From: Laura Gibbons
Sent: 23 January 2019 16:04
To: Planning.Responses
Cc: Simon Davis
Subject: RE: Planning Consultation on: Y/103/18/PL

Engineers Comments Regarding Surface Water Drainage

APPLICATION NO: Y/103/18/PL

Description of Works: Single Chapel Crematorium with car parking, landscape works, surface water drainage features & associated highway improvements. This application is a Departure from the Development Plan.

Drainage Strategy Layout

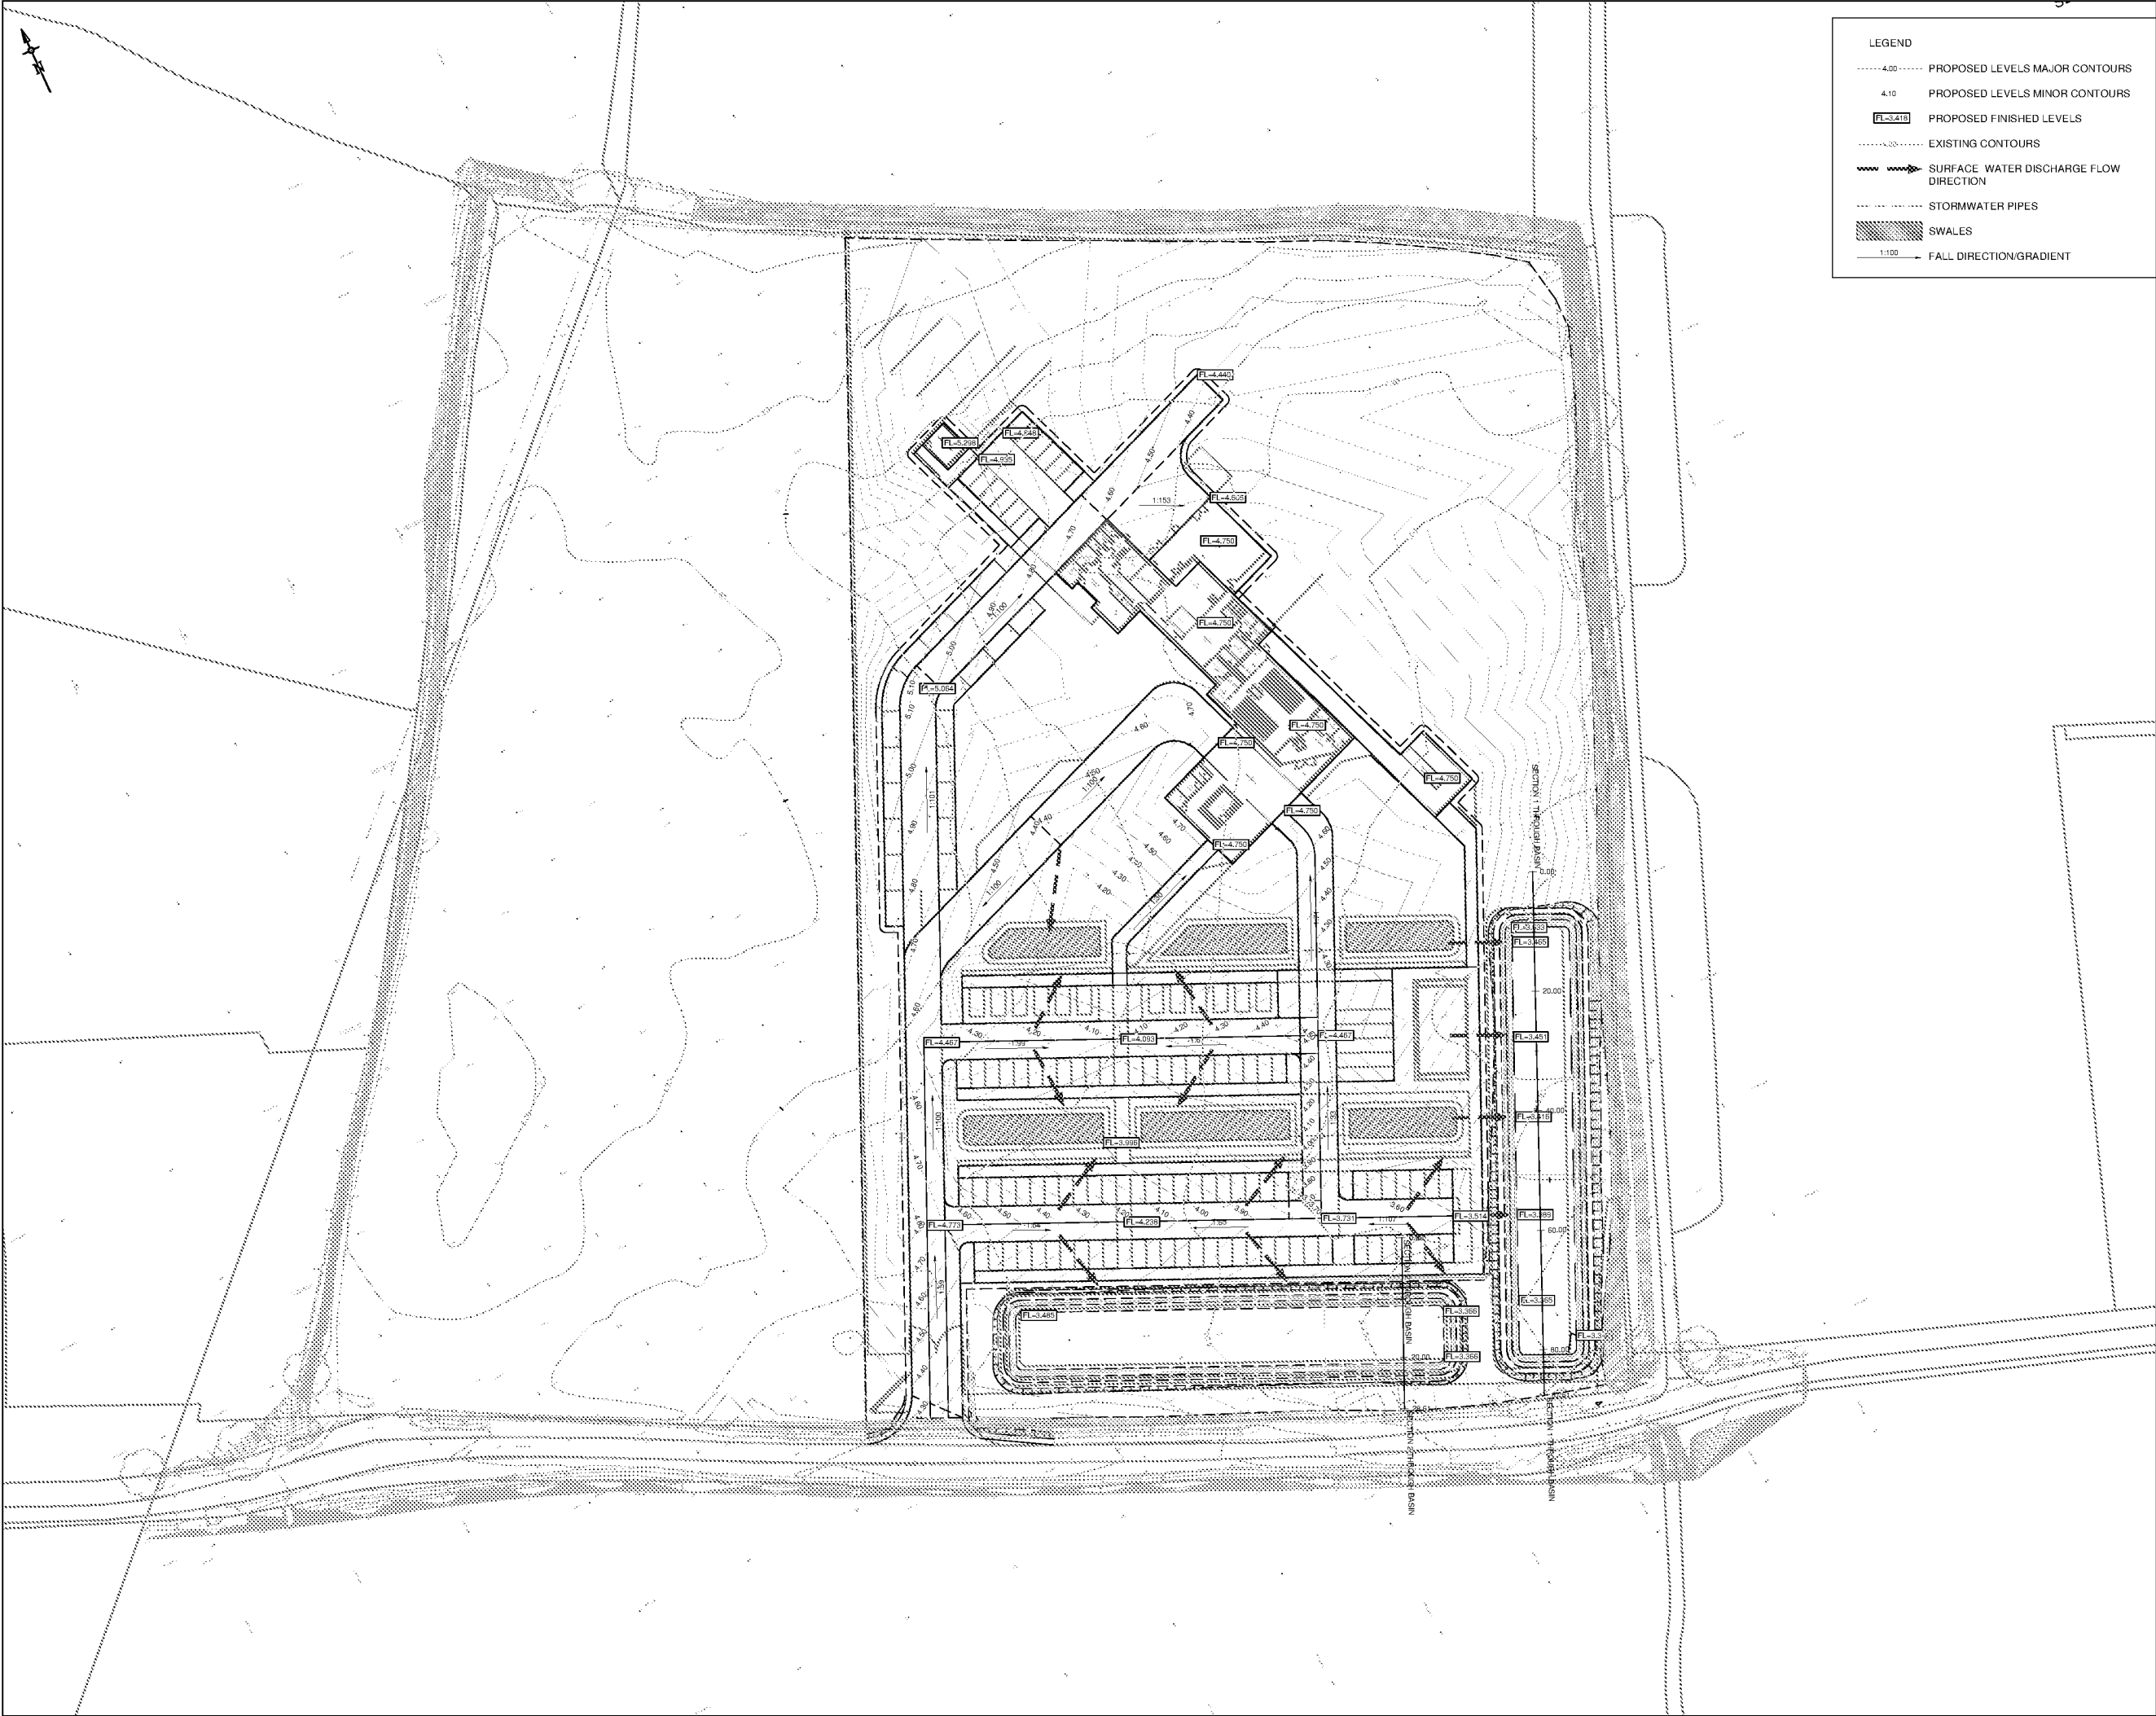
Attenuated discharge is proposed for the site. It must be demonstrated that infiltration has been fully investigated prior to attenuated discharge being agreed.

Infiltration rates for soakage structures are to be based on percolation tests undertaken in the winter period and at the location and depth of the proposed structures. The percolation tests must be carried out in accordance with BRE 365, CIRIA R156 or a similar approved method and cater for the 1 in 10 year storm between the invert of the entry pipe to the soakaway, and the base of the structure. It must also have provision to ensure that there is capacity in the system to contain below ground level the 1 in 100 year event plus 40% on stored volumes, as an allowance for climate change. Adequate freeboard must be provided between the base of the soakaway structure and the highest recorded annual groundwater level identified in that location.

Any SuDS or soakaway design must include adequate groundwater monitoring data to determine the highest winter groundwater table in support of the design. The applicant is advised to discuss the extent of groundwater monitoring with the Council's Engineers. Supplementary guidance notes and our surface water drainage submissions checklist are also enclosed for information.

Please apply **ENGD2B, ENGD4A, ENGD5A and ENGD6A.**
